## **RMG Response Letter to—Development Plan and Final Plat for Northcrest Flex Space PPR**

**PCD File No.: PPR-21-036**

### **Fifth Review Letter**

Subject: Northcrest Flex Space  
2510 and 2522 Canada Drive  
Colorado Springs, CO 80922

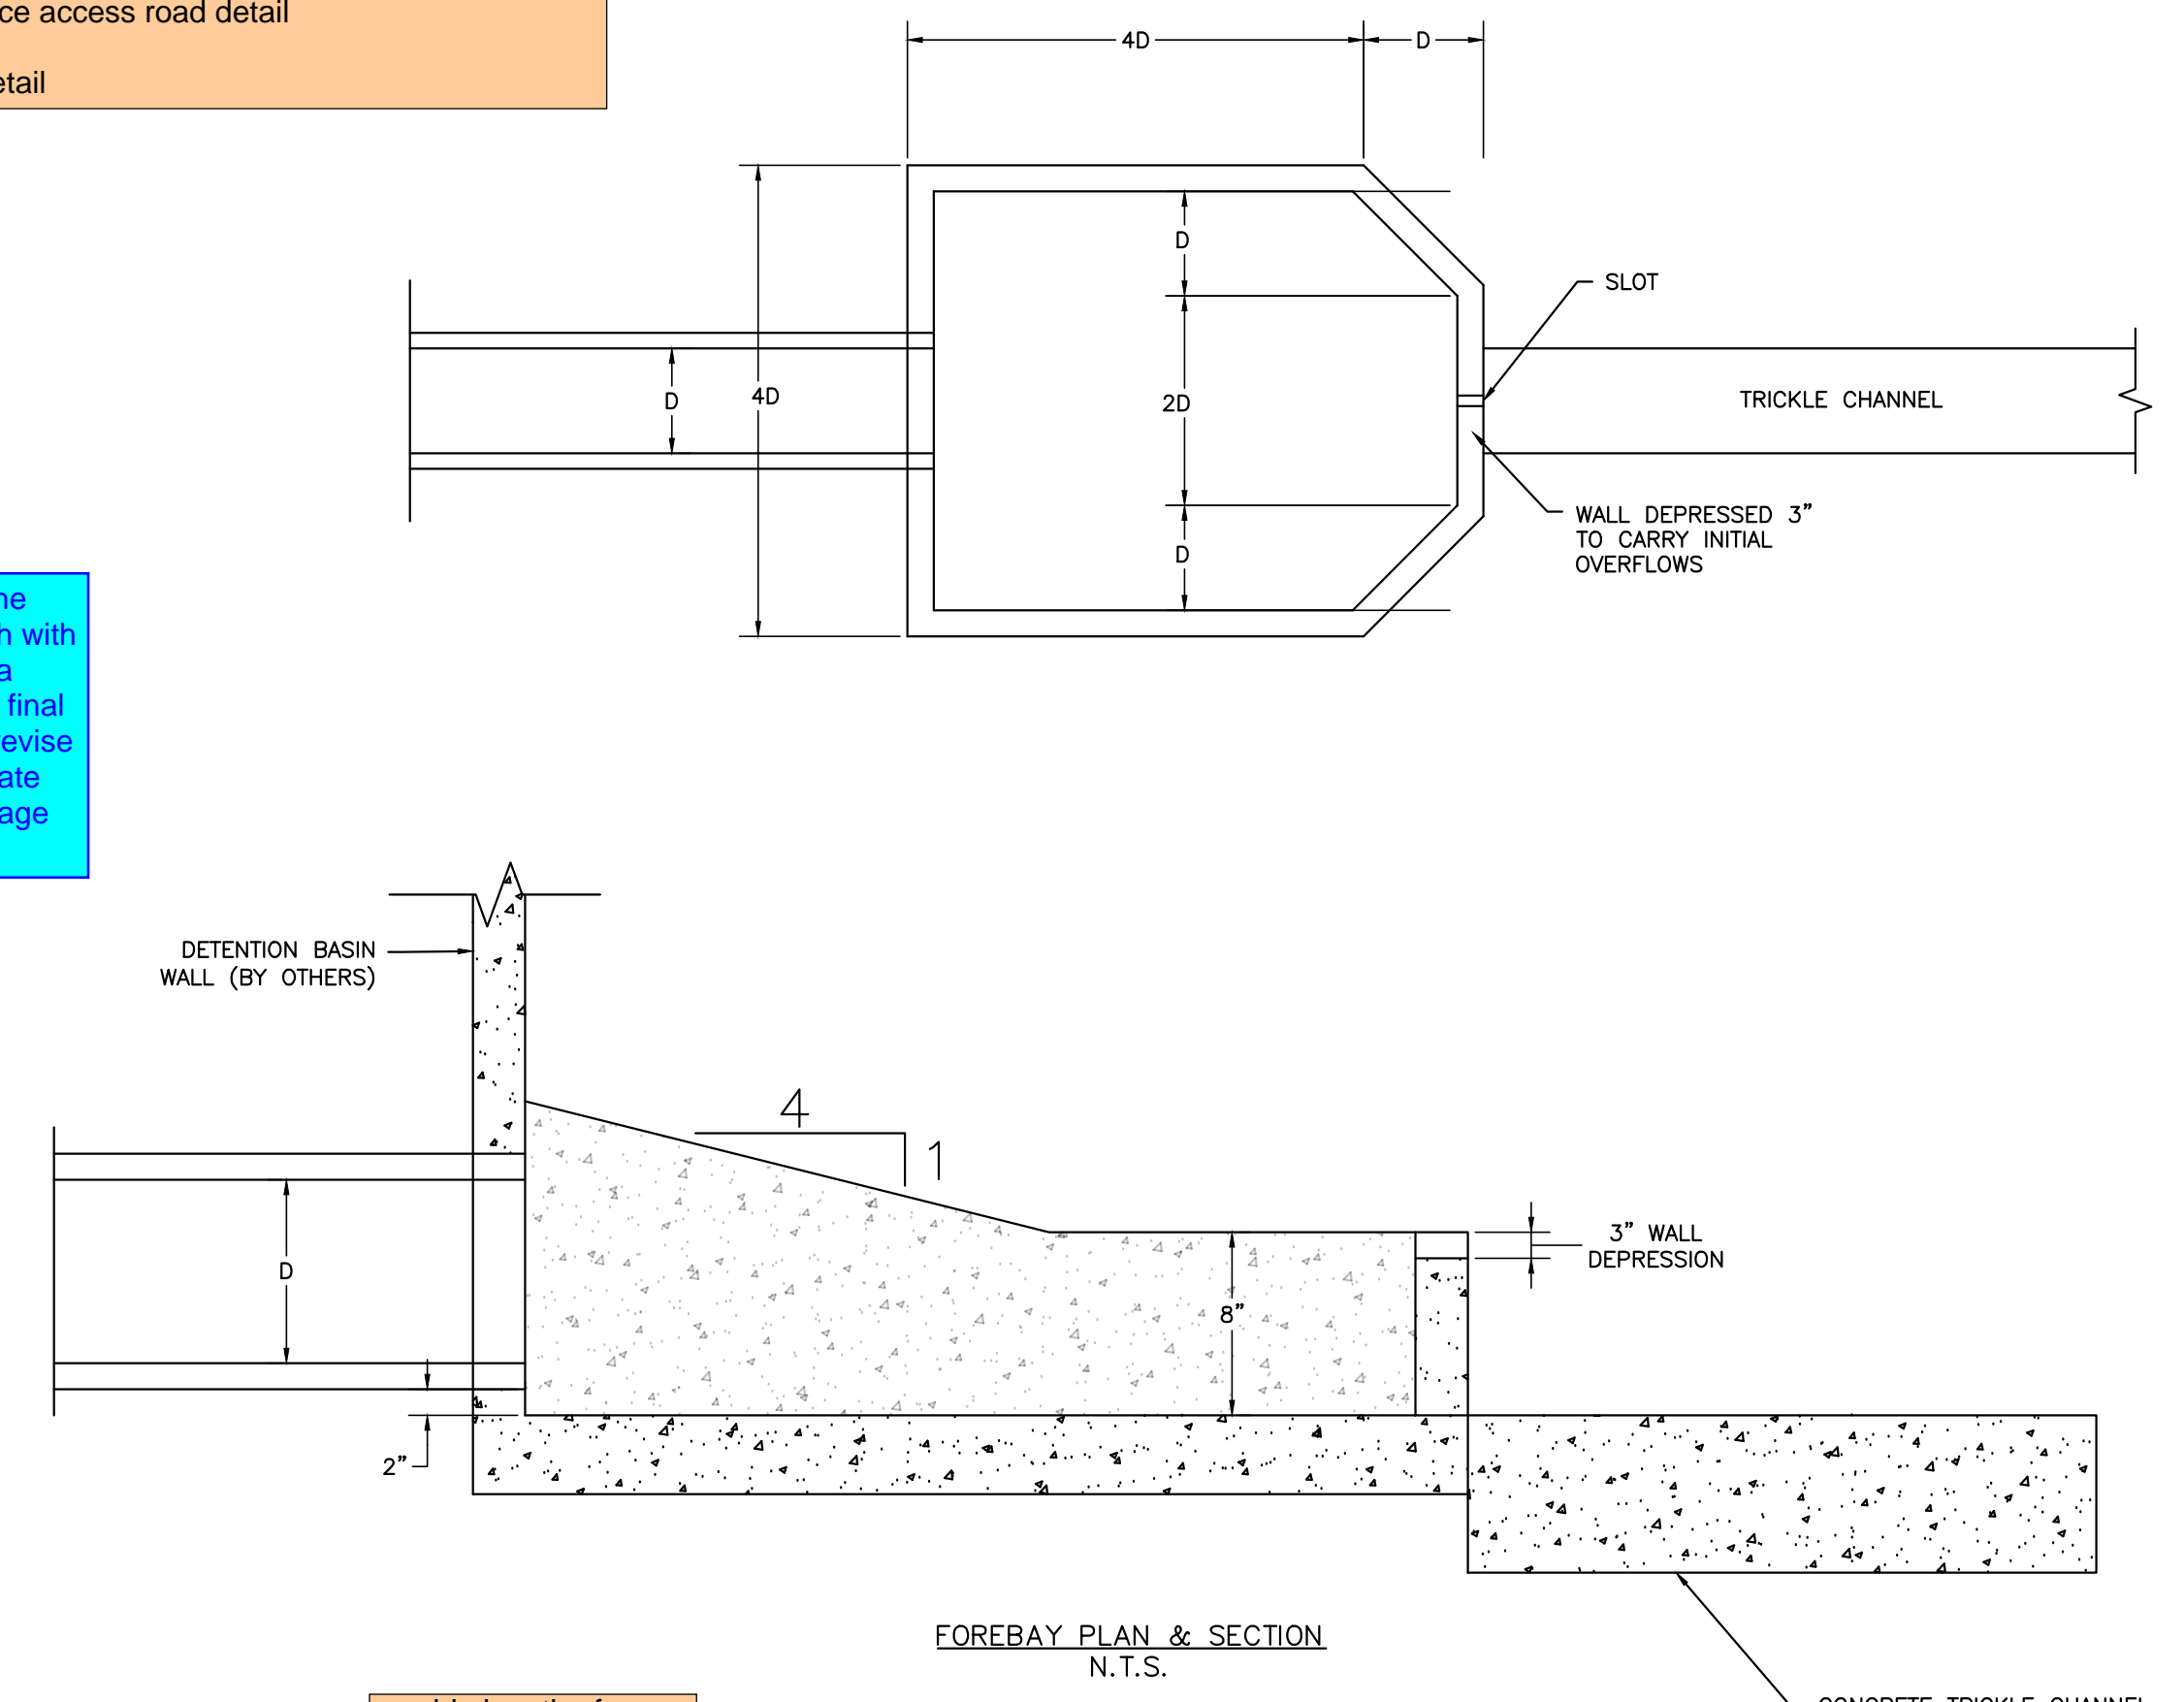
9. The shown diameter of the orifice holes do not match with the calculated orifice area shown on page 35 of the final drainage report. Please revise orifice plate detail or update calculations in final drainage report.

**RMG: The plan sheets and drainage report have been revised to match.**

JOB NO: 180649
SHEET NO: DP.02

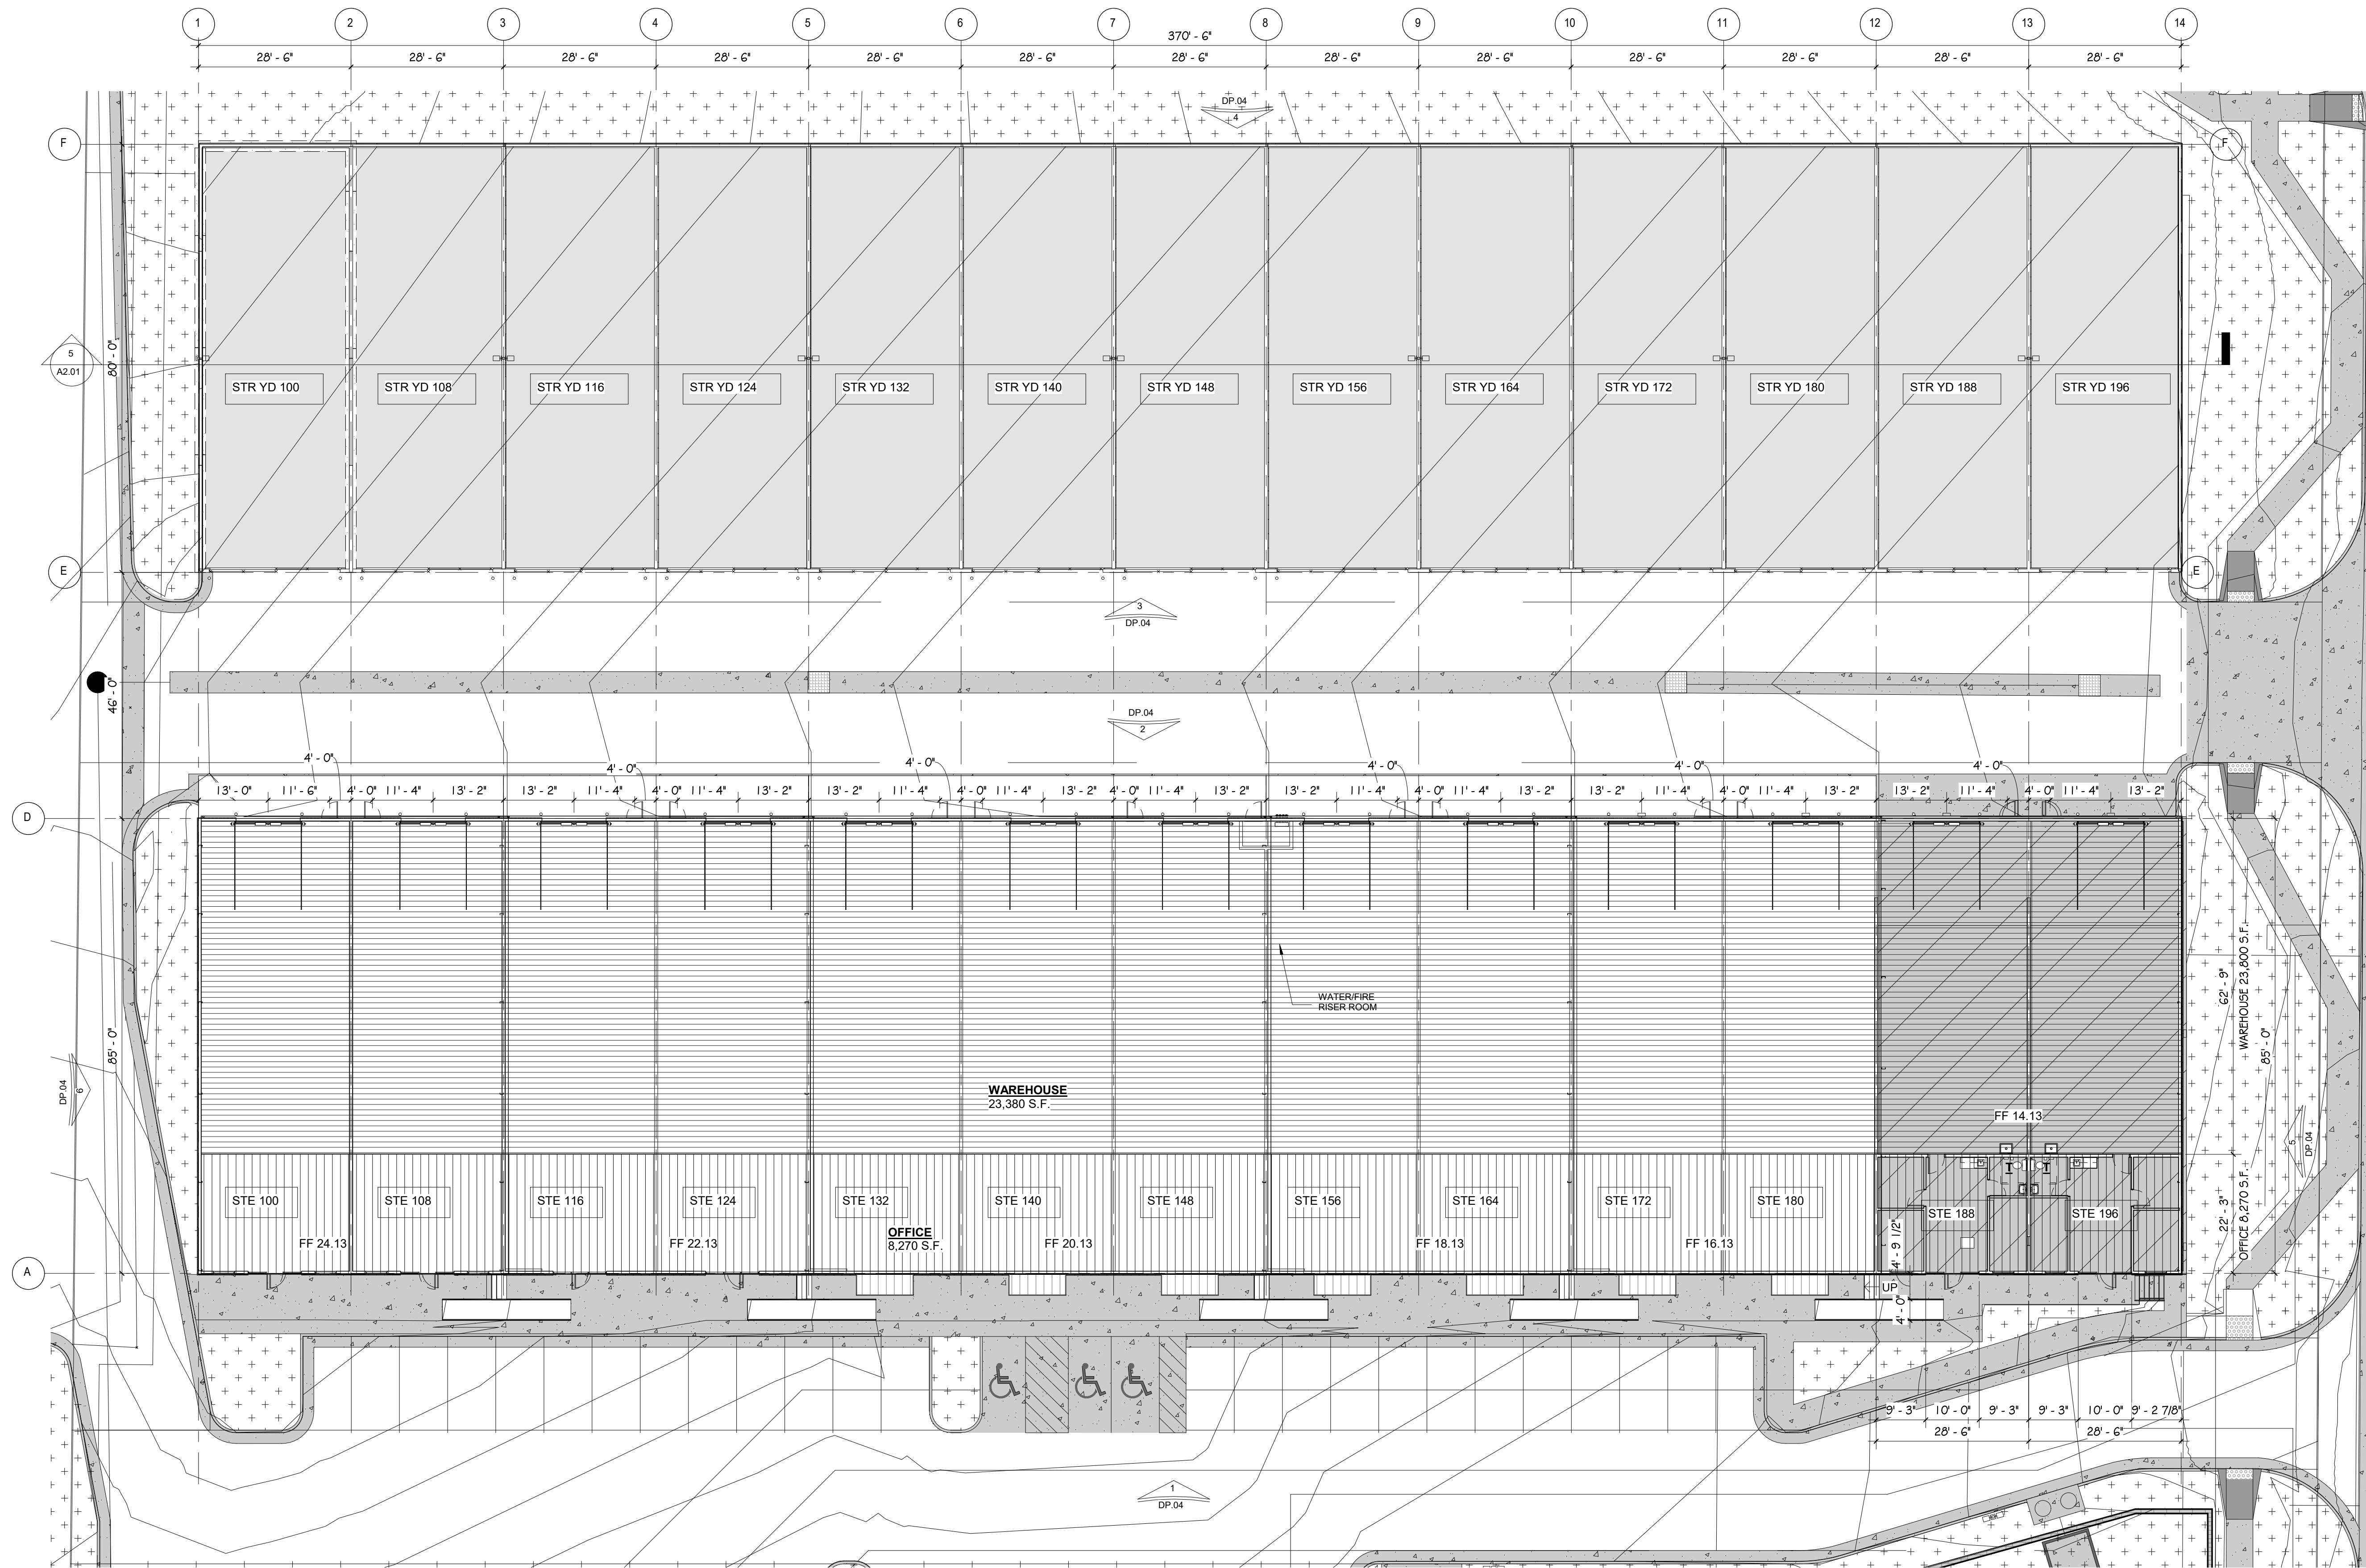
1. Please label this hatching and update the legend.

**RMG: A label has been added to show these loading stalls.**
